Application for Planning Permission

Development: Second & third storey extensions to existing care home to provide 14 No. new residential care rooms. This application may affect the setting of listed building, affects the character & appearance of the East Street Conservation Area & is in CIL Zone 4 (Zero Rated) as other development.

Location: Mewsbrook House 59 East Street Littlehampton BN17 6AU

DRAWING TITLE: EXISTING FIRST FLOOR PLAN

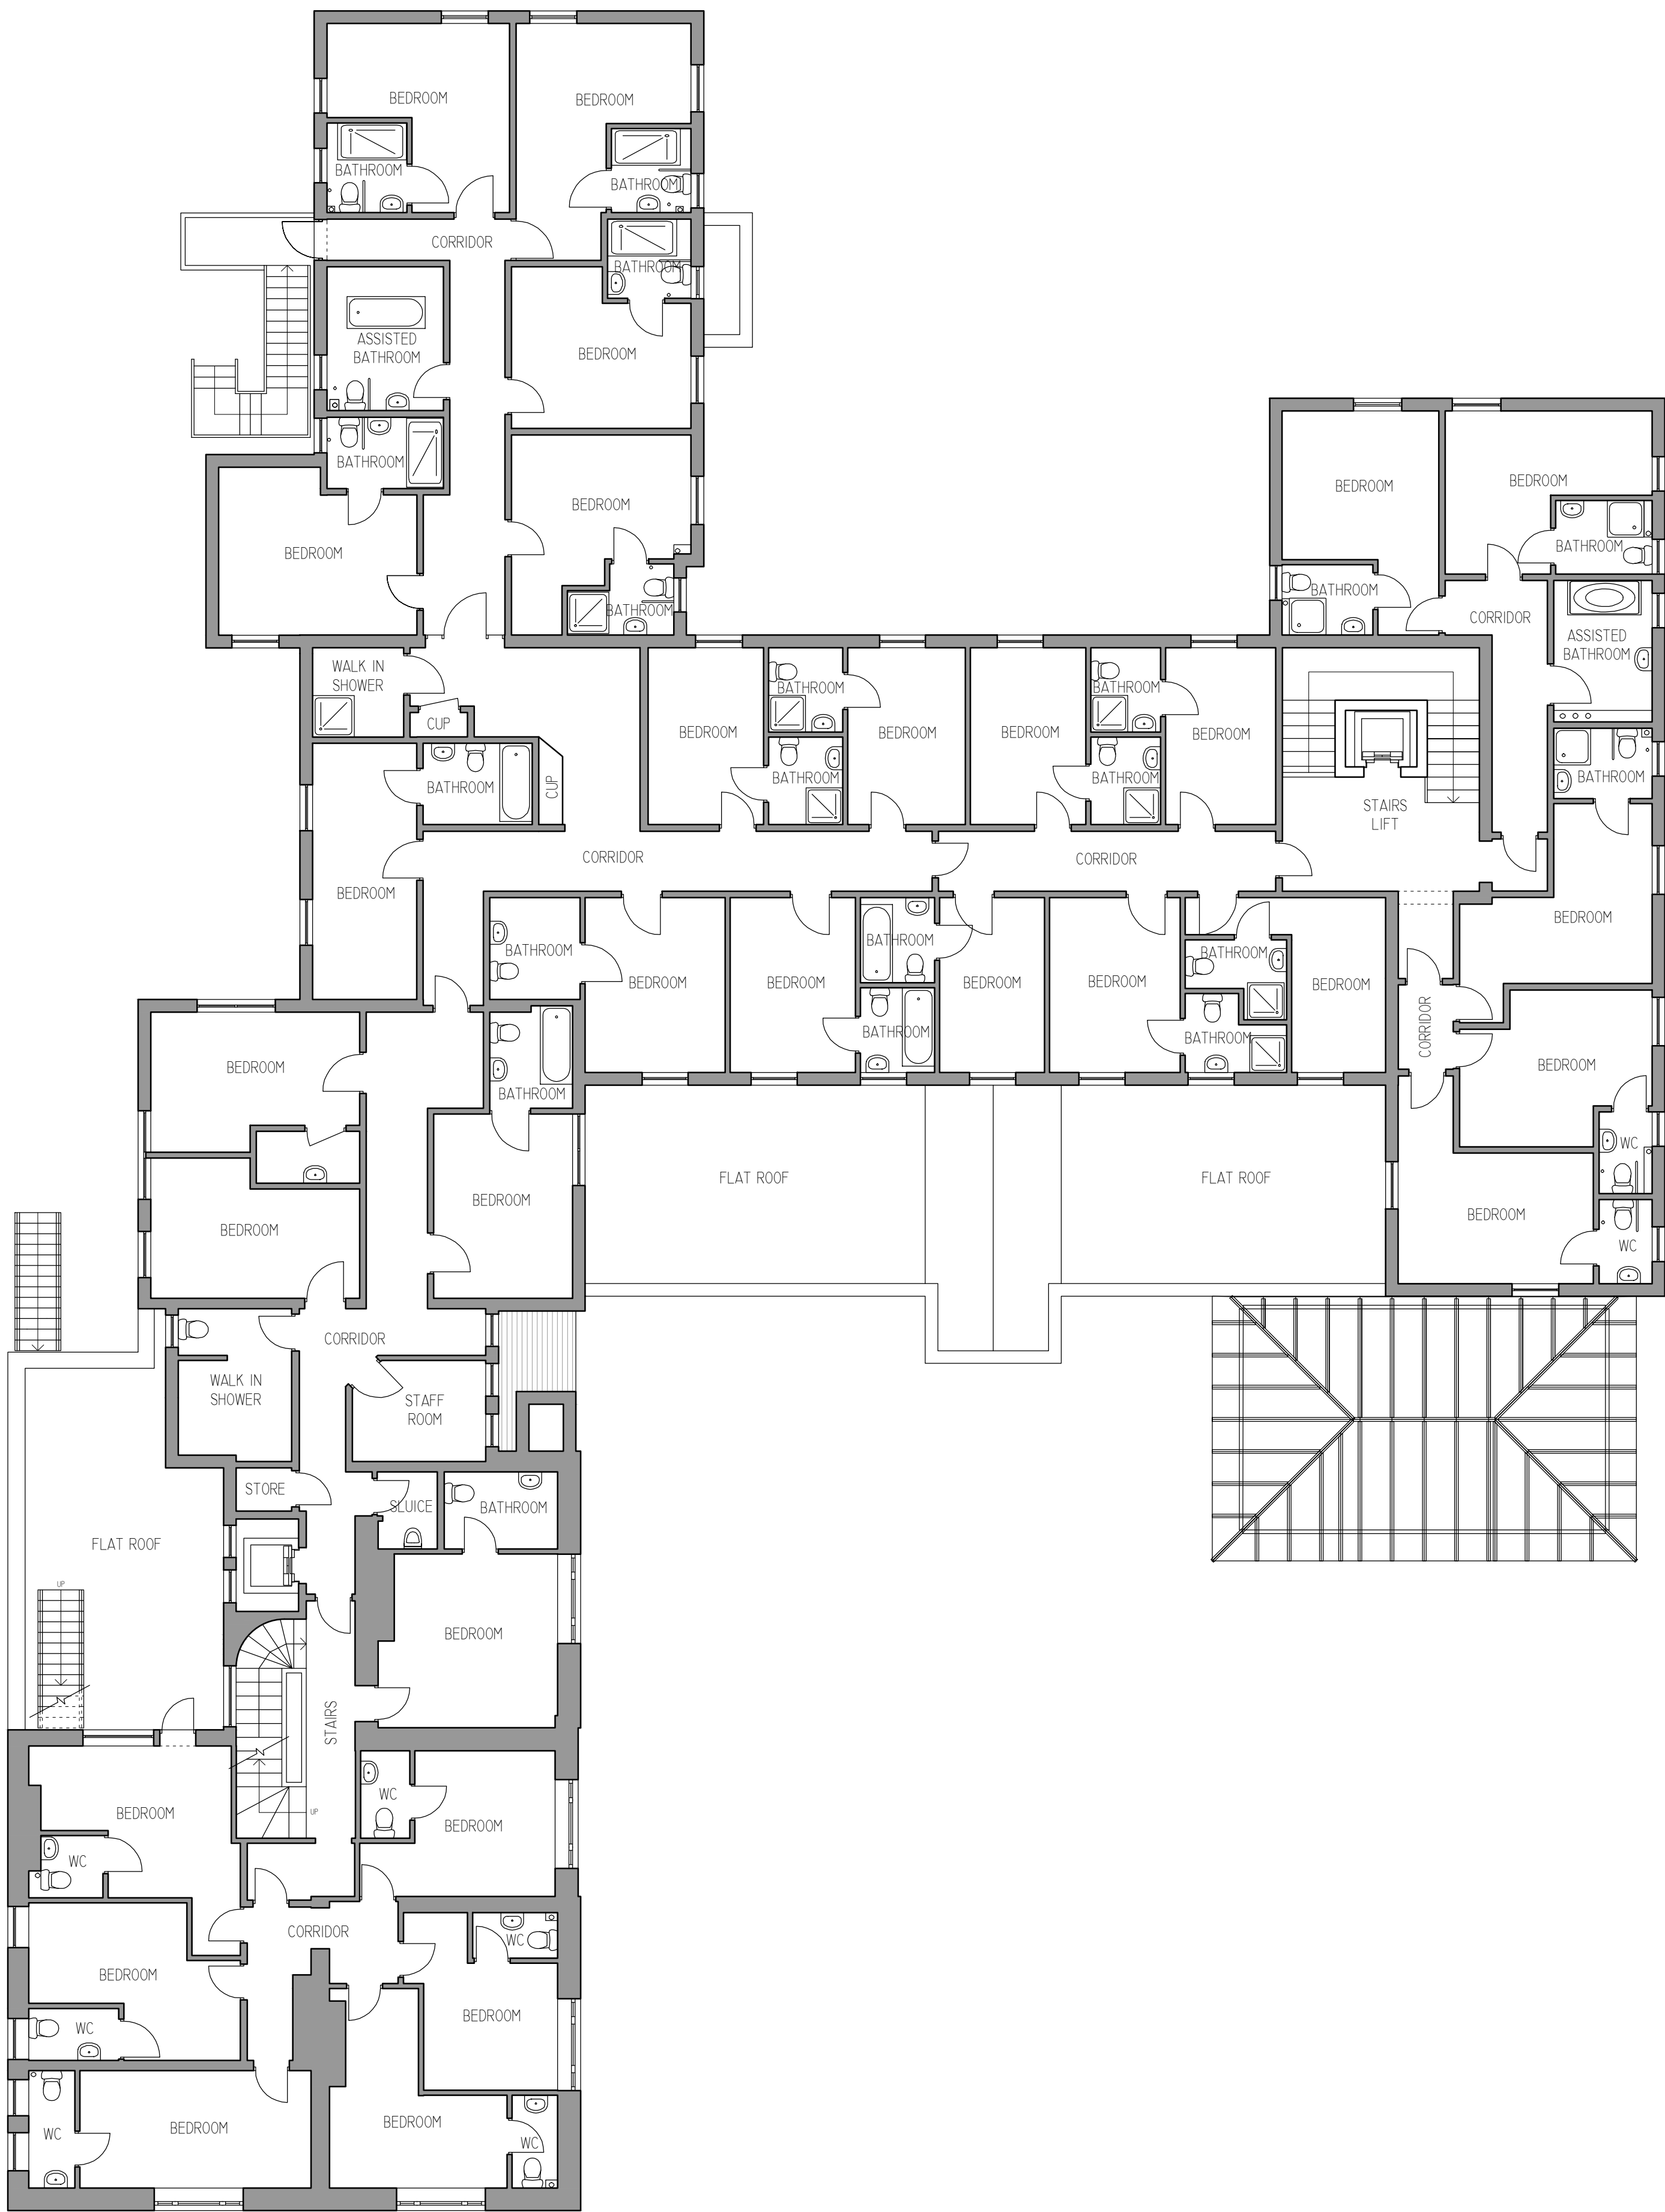
The existing and proposed West elevation B and first floor plan do not accord. Please amend accordingly.

The existing and proposed West elevation A and first floor do not accord. Please amend accordingly.

DRAWING TITLE
PROPOSED GROUND FLOOR PLAN

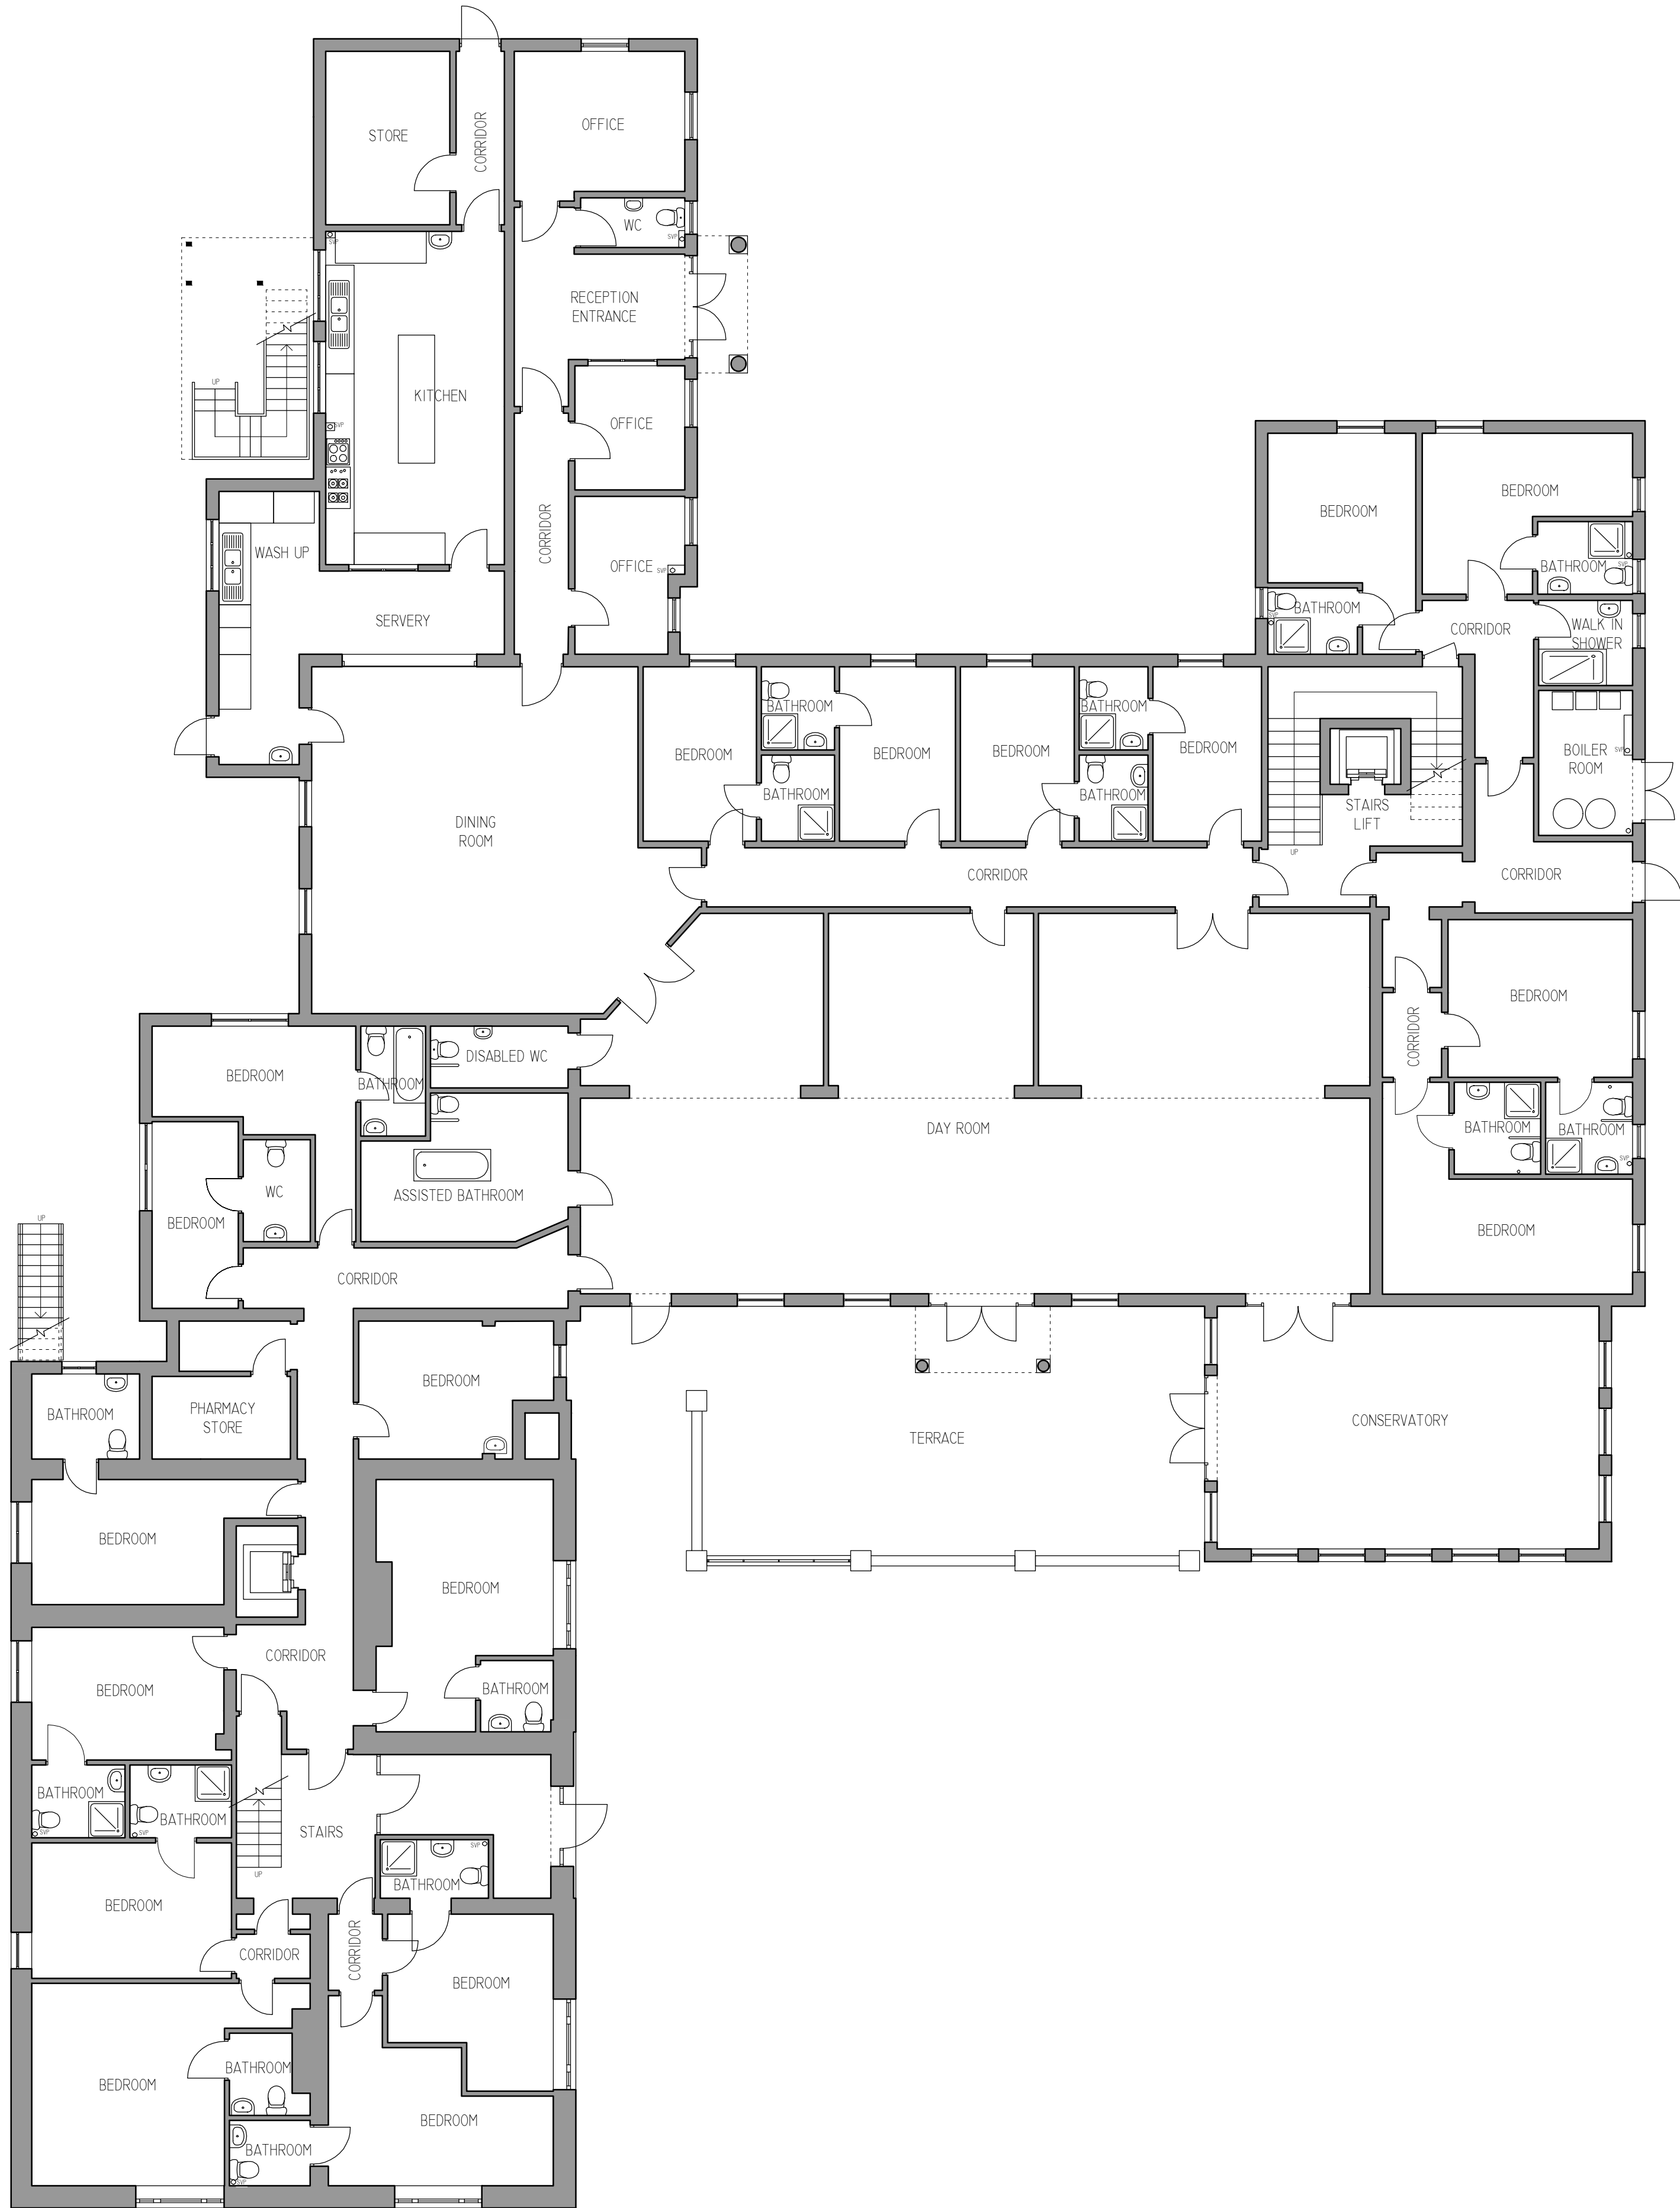
The existing and proposed East elevation and ground floor plan do not accord. Please amend accordingly.

the existing and proposed South elevation and ground floor plan do not accord. Please amend accordingly.

The existing and proposed West elevation A and ground floor plan do not accord. Please amend accordingly.

DRAWN BY: EL
DATE: 3RD JUN 2021
DRAWING TITLE: EXISTING SECOND FLOOR PLAN
SCALE: 1:100 @ A1
DRAWING NO: E106

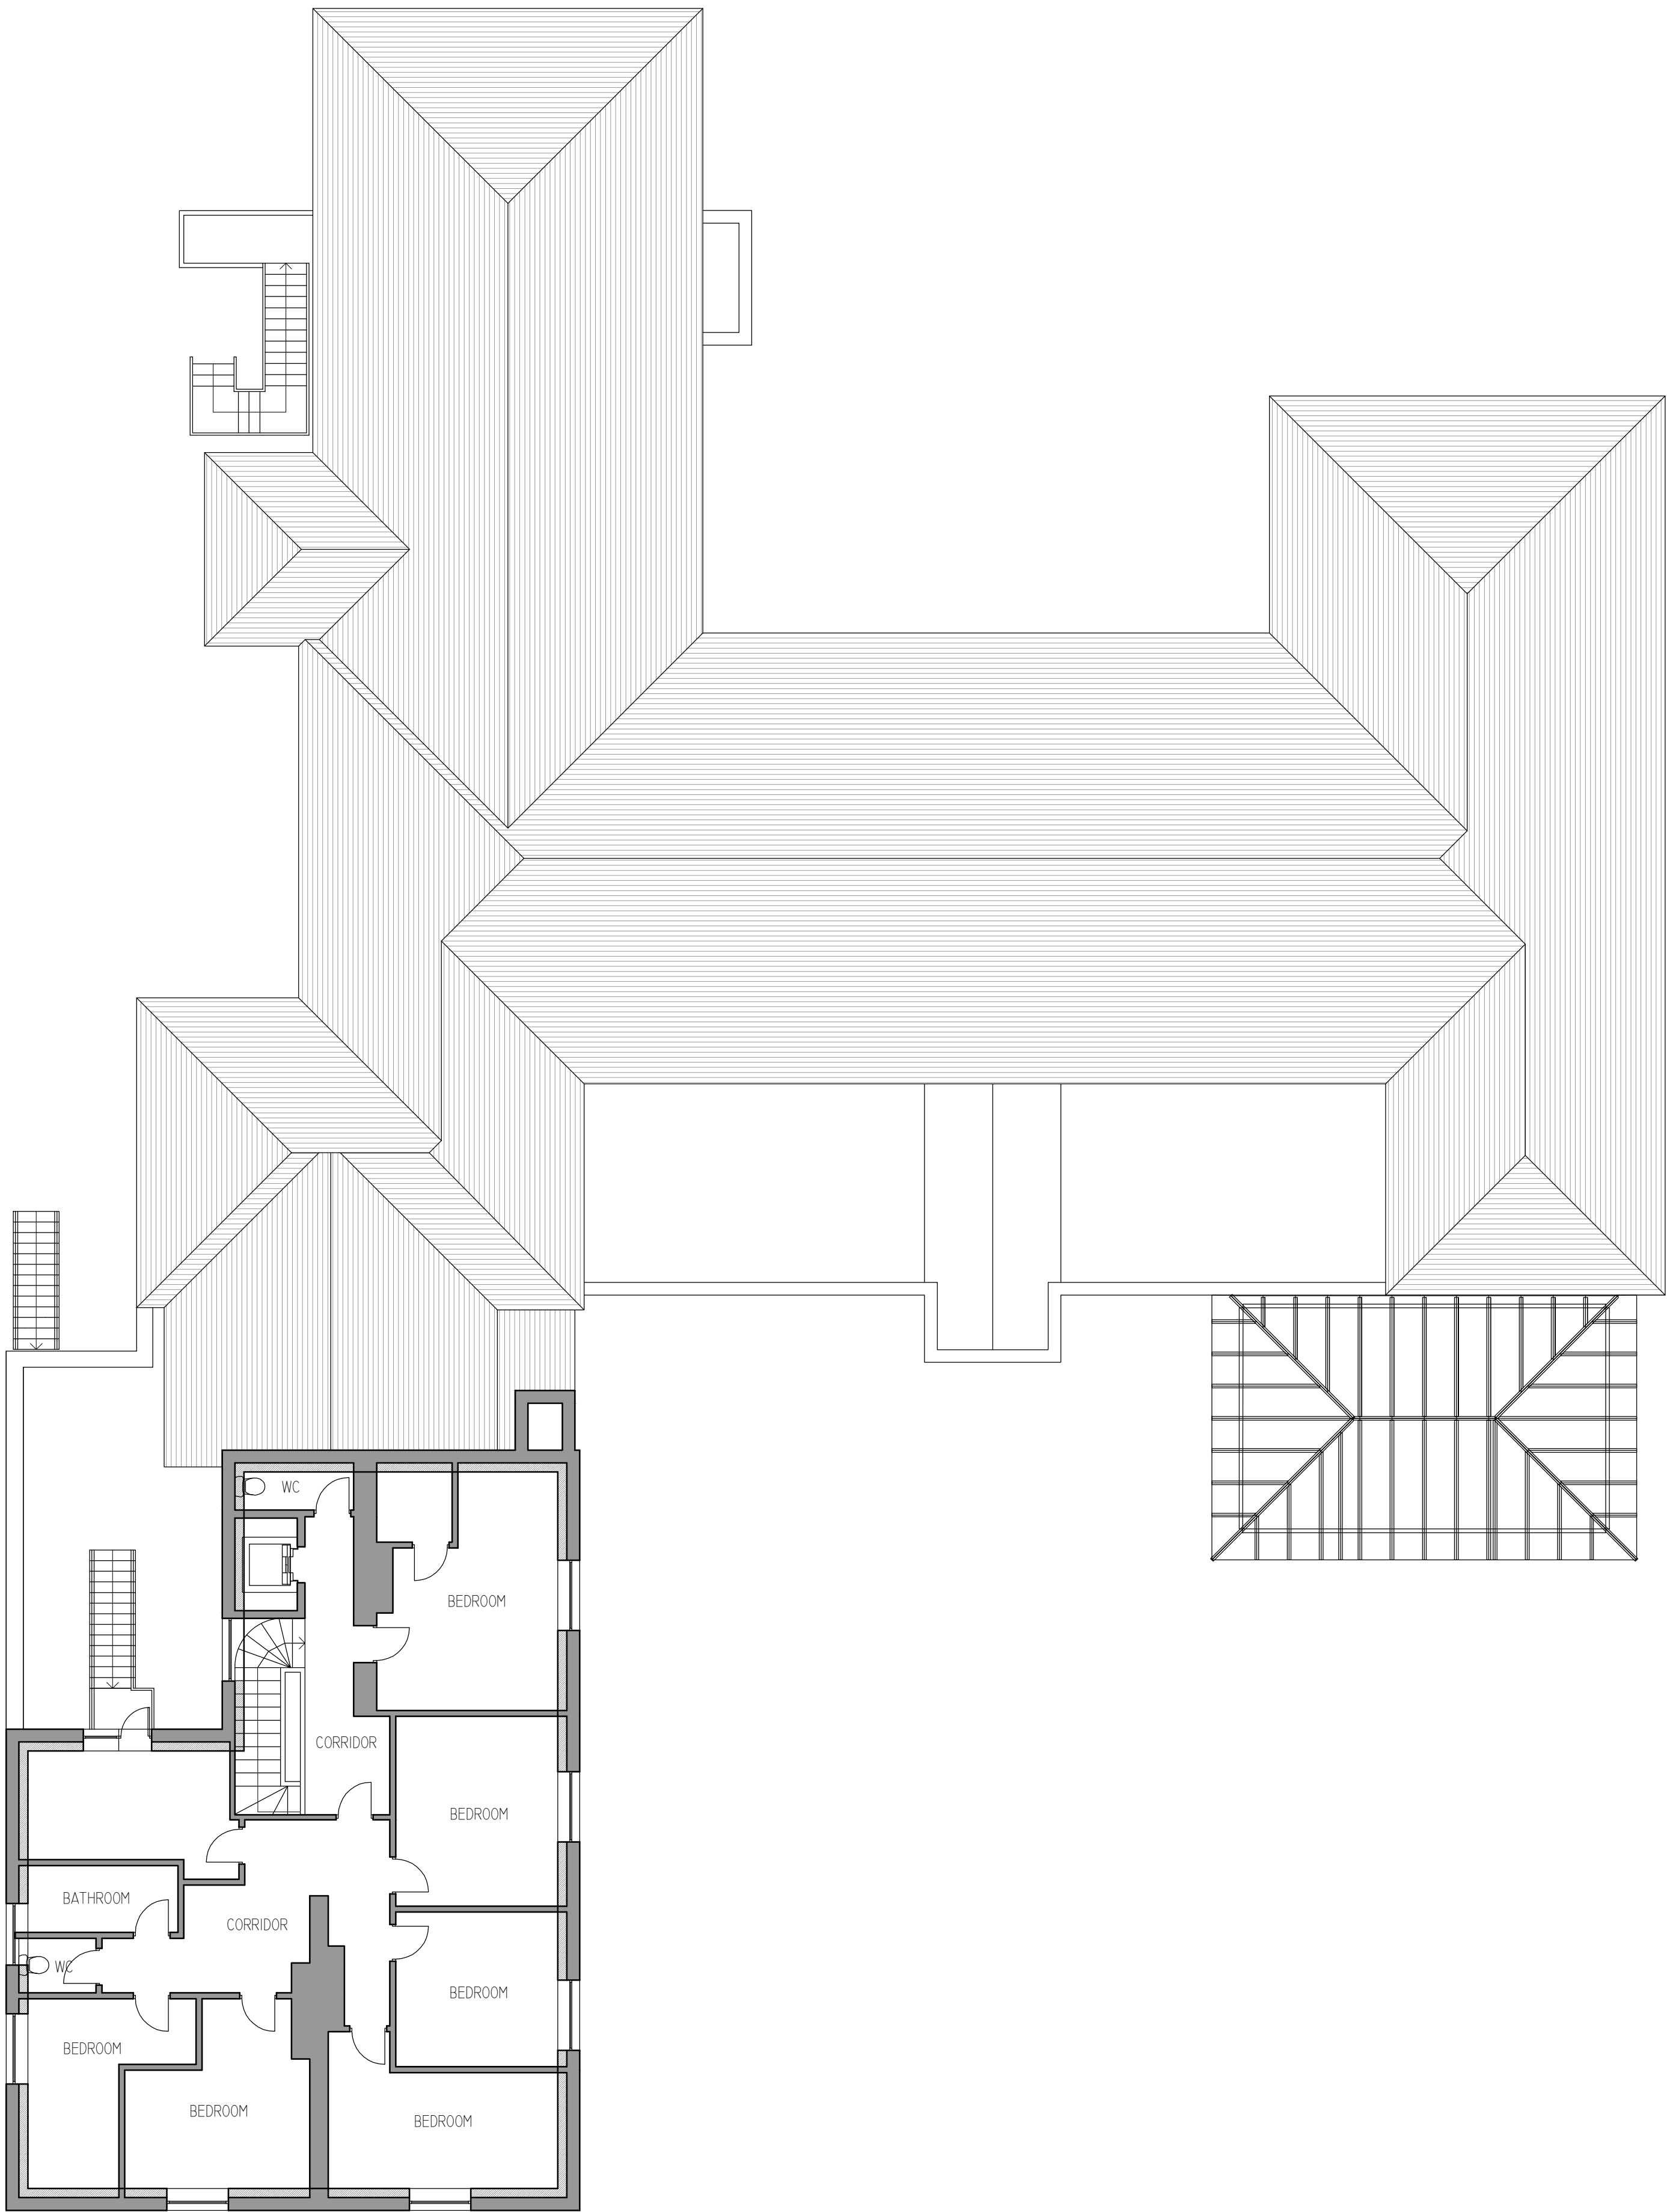
Please provide an existing second floor plan.
